Highways England Planning Response (HEPR 16-01)

Council's Reference: A/100/19/PL

Location: Arundel Acre, Arundel Road, Angmering.

Proposal: Change of use of land from agriculture for 3 No. travelling showpeople plots (Sui Generis) with associated storage barn, maintenance area, landscaping & infrastructure.

Appendix D – Drawing No: JNY10317/02

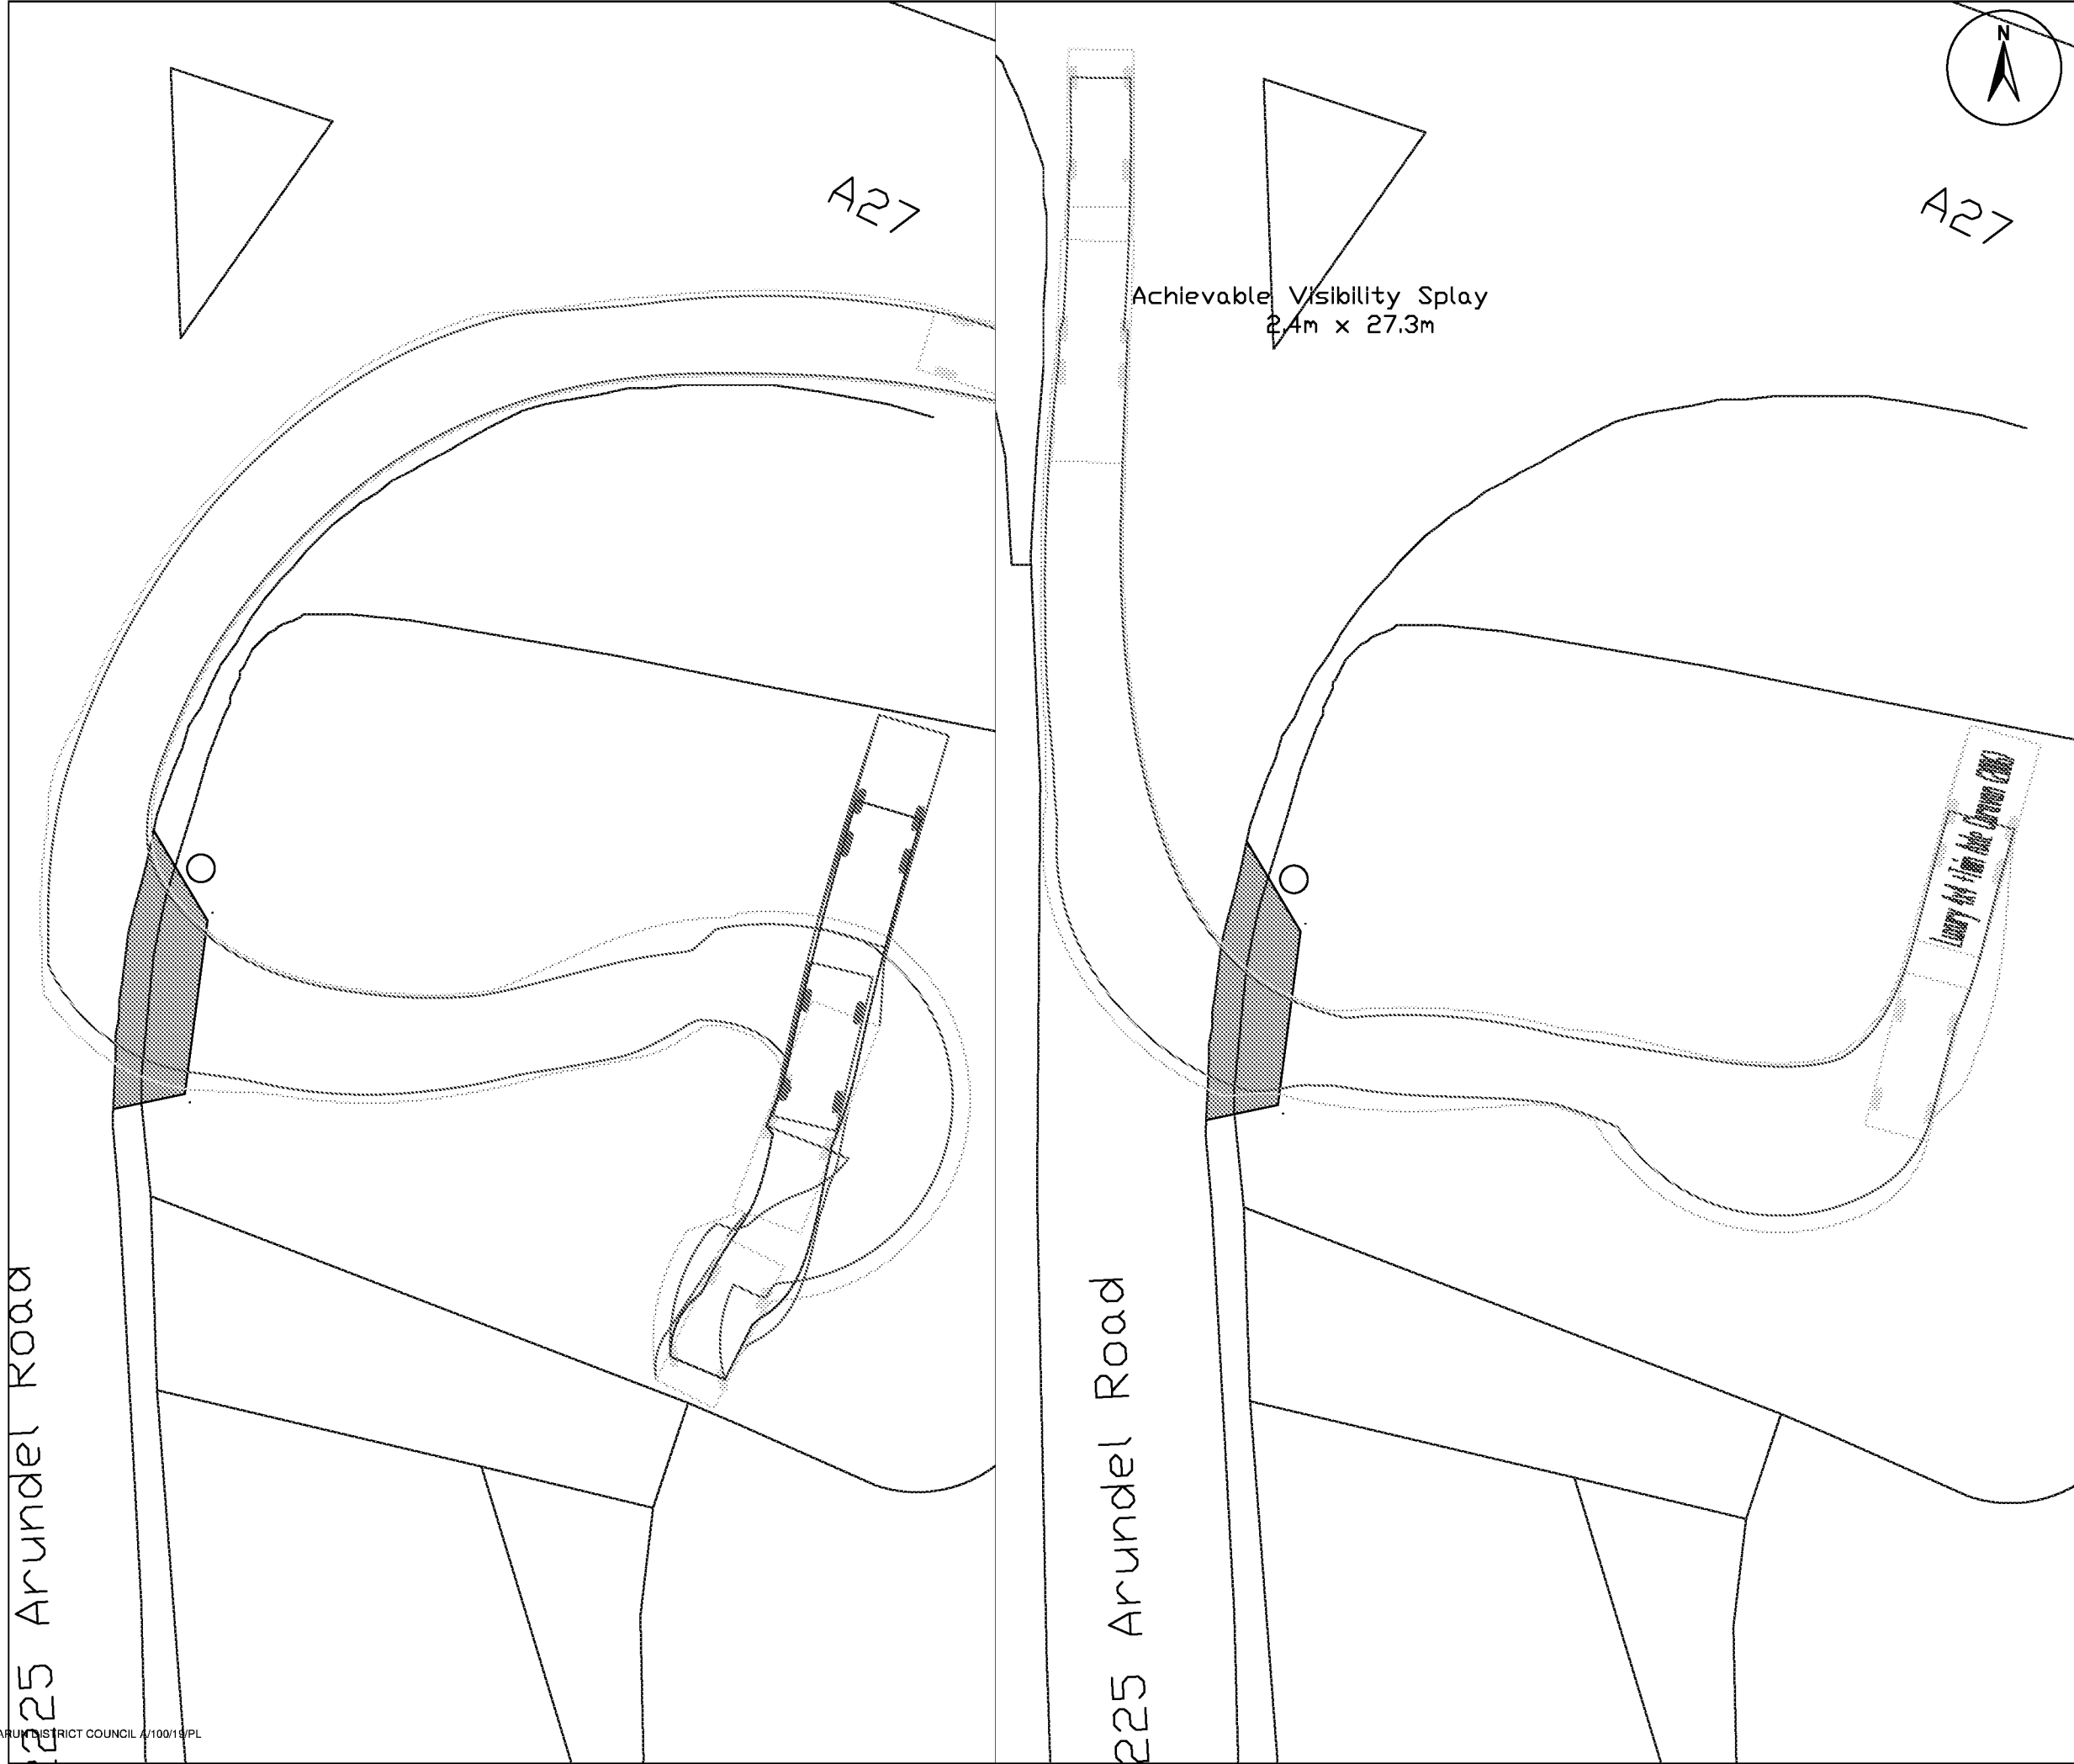
- 1) Within 1 month of permission being granted for the development, a further visibility splay plan will be provided to the Local Planning Authority (who shall consult Highways England) that shows the visibility splay all the way around the bend, and not just from the site access, in order that a Safe Stopping Distance can be achieved around the corner in relation any part of the vehicle and trailer shown in the swept path plan manoeuvring into and out of the access.

RPS Drawing/Figure Number	Rev
JNY10317/01a	-

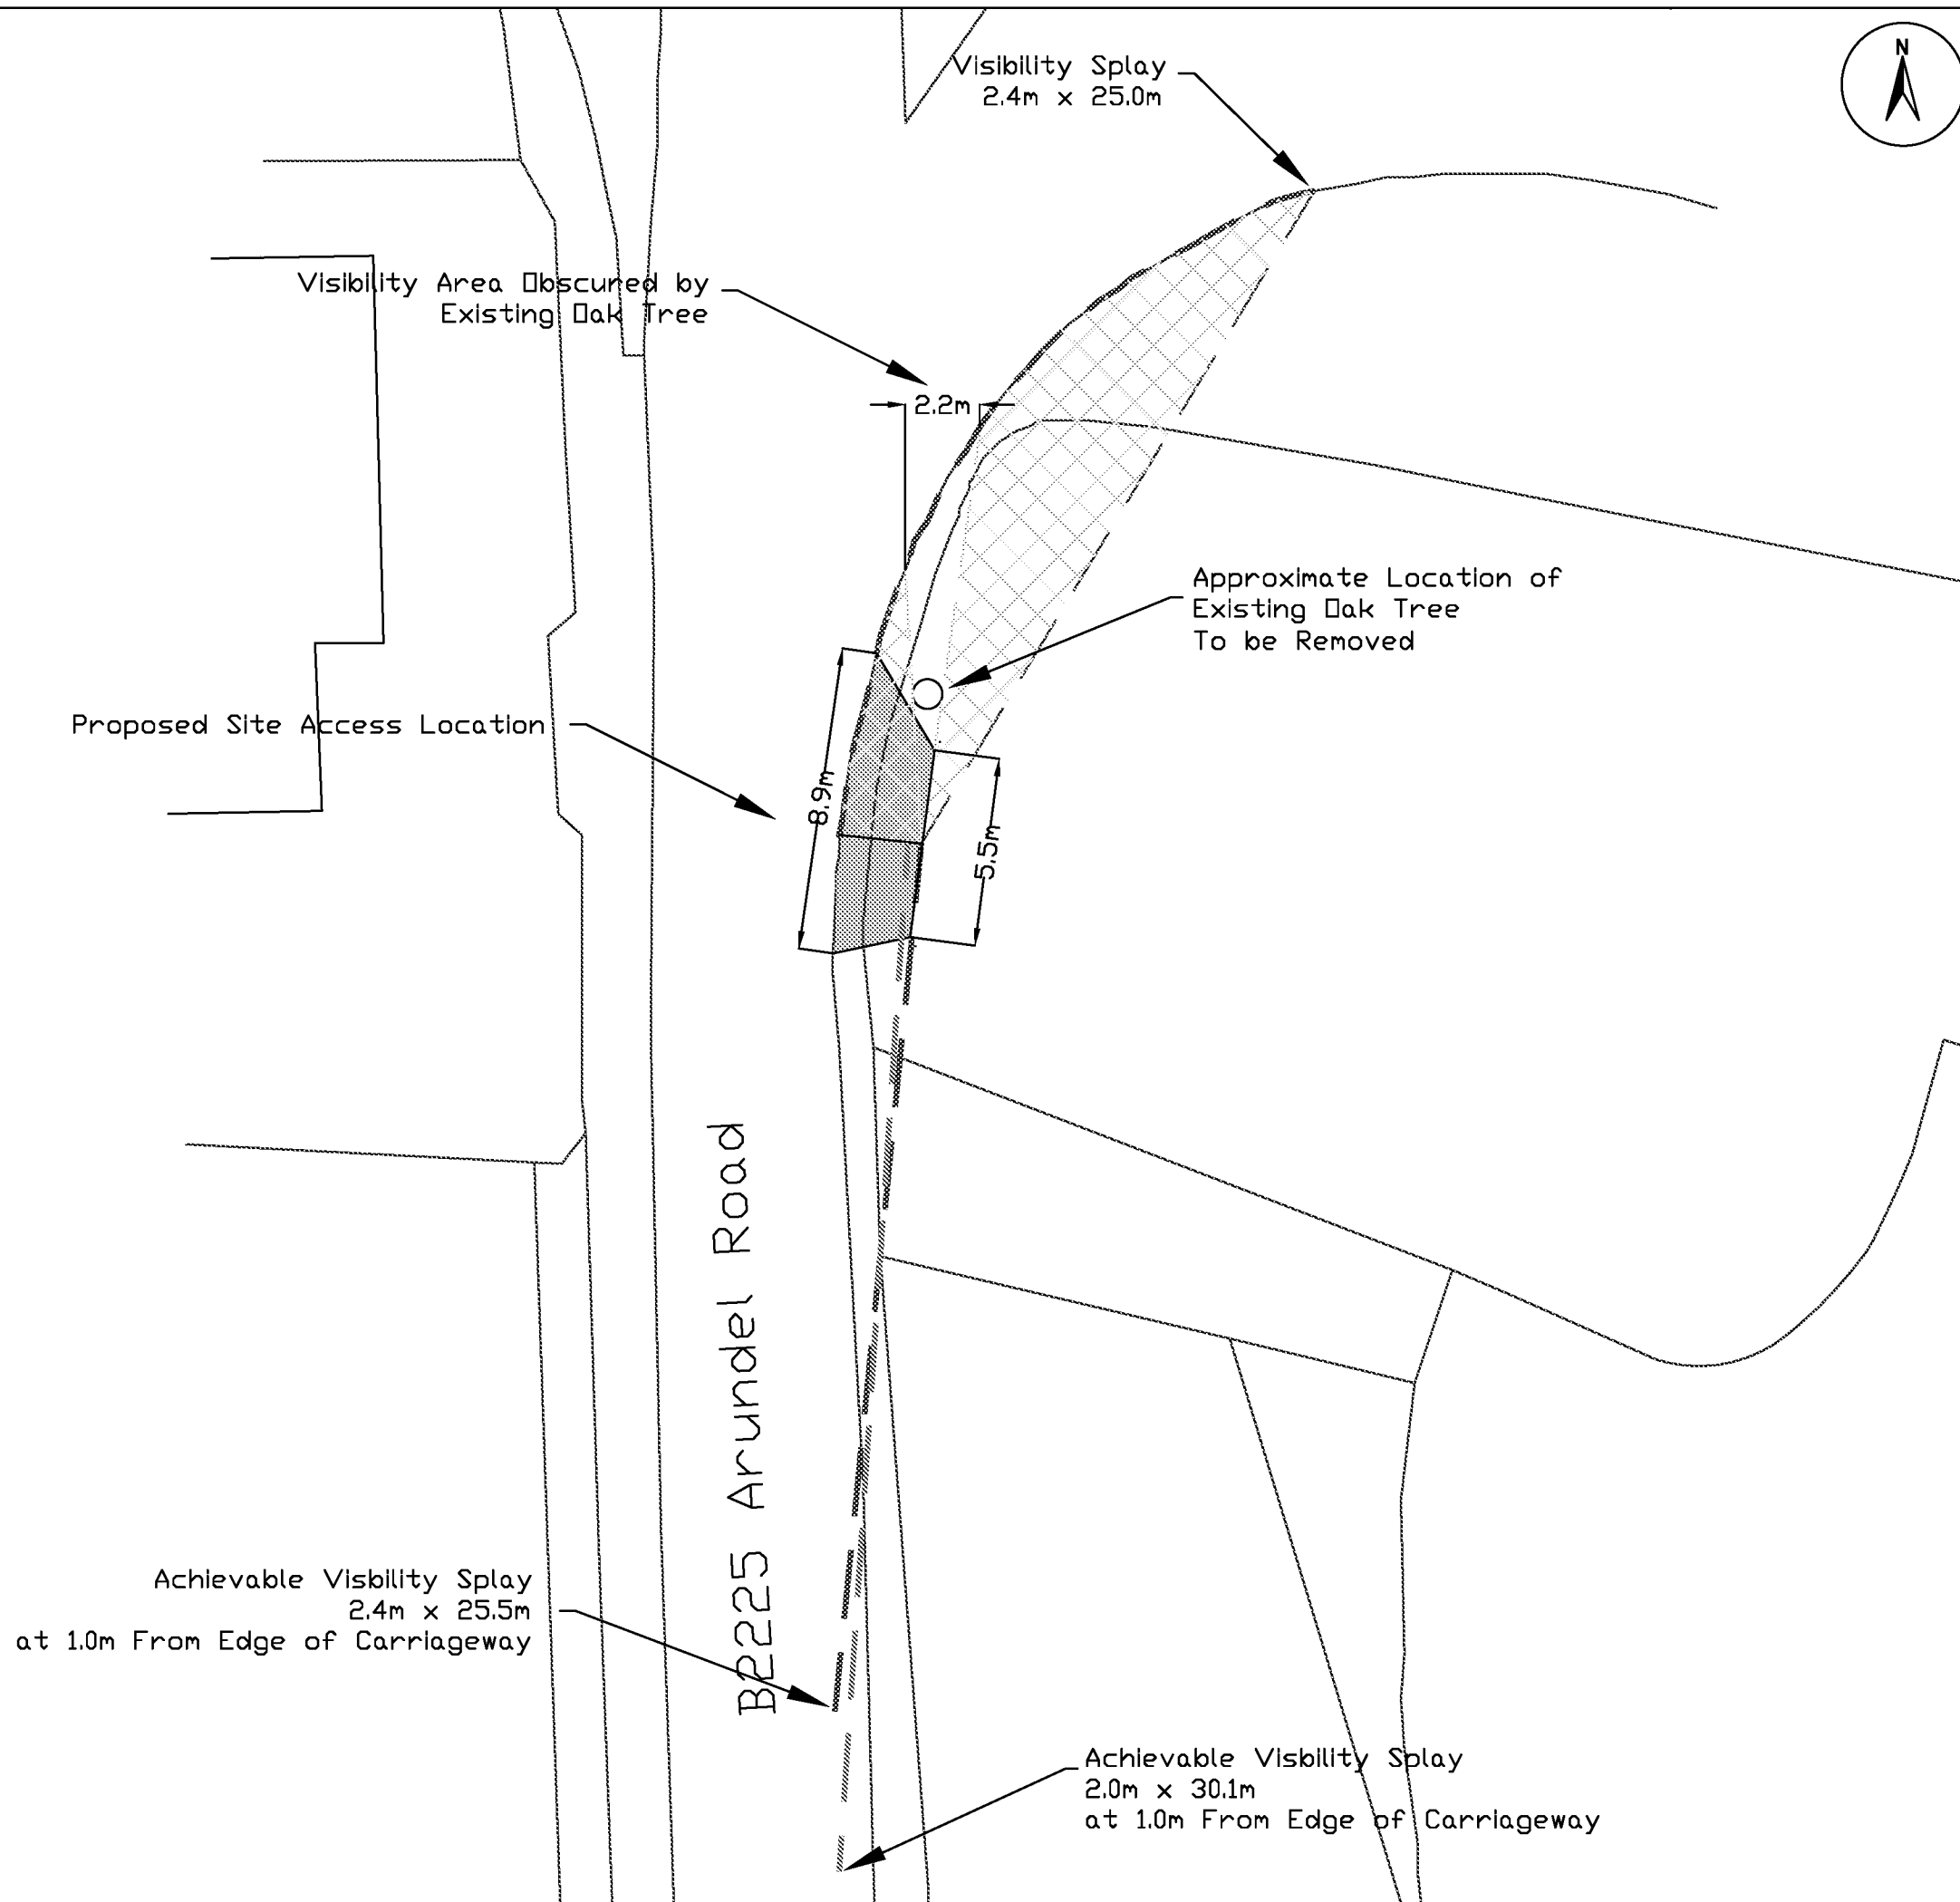
shortened and is not equivalent. The revised access is now on the apex of the bend's radius with associated limited visibility for vehicles manoeuvring in or out of the access.

We have been advised that no further information will be provided at this stage, and therefore, based on the information provided, Highways England will require conditions to be placed on any permission that require a further plan to be provided that shows the visibility splay all the way around the bend (not just from the site access), in order that a Safe Stopping Distance can be achieved around the corner in relation to any part of the vehicle and trailer shown in the swept path plan (Drawing No. JNY10317/02) manoeuvring into and out of the access. In this respect, please note that Manual for Streets is not appropriate for use associated with trunk roads or where speed limits are above 40mph. As such, the visibility splay will need to be provided in accordance with the results of the speed survey and DMRB calculations.

All vegetation within the visibility splay, including the oak tree, will need to be cleared and maintained in perpetuity so that the sightline can be achieved and maintained for the proposal to be acceptable. Such a plan will need to be provided to Arun District Council as the Local Planning Authority, who shall consult Highways England accordingly. As this is a retrospective application, the plan will need to be provided and agreed within 1 month of any permission, with the vegetation cleared before the bird breeding season and within 2 months of any permission.

- 2) Before the bird breeding season and within 2 months of permission being granted for the development, all vegetation, including the oak tree, within the agreed visibility splay (as subject to condition 1) will be cleared, and the area of the visibility splay within the applicant's site boundary thereafter will be maintained in perpetuity so that the sightline associated with the visibility splay can be achieved and maintained.
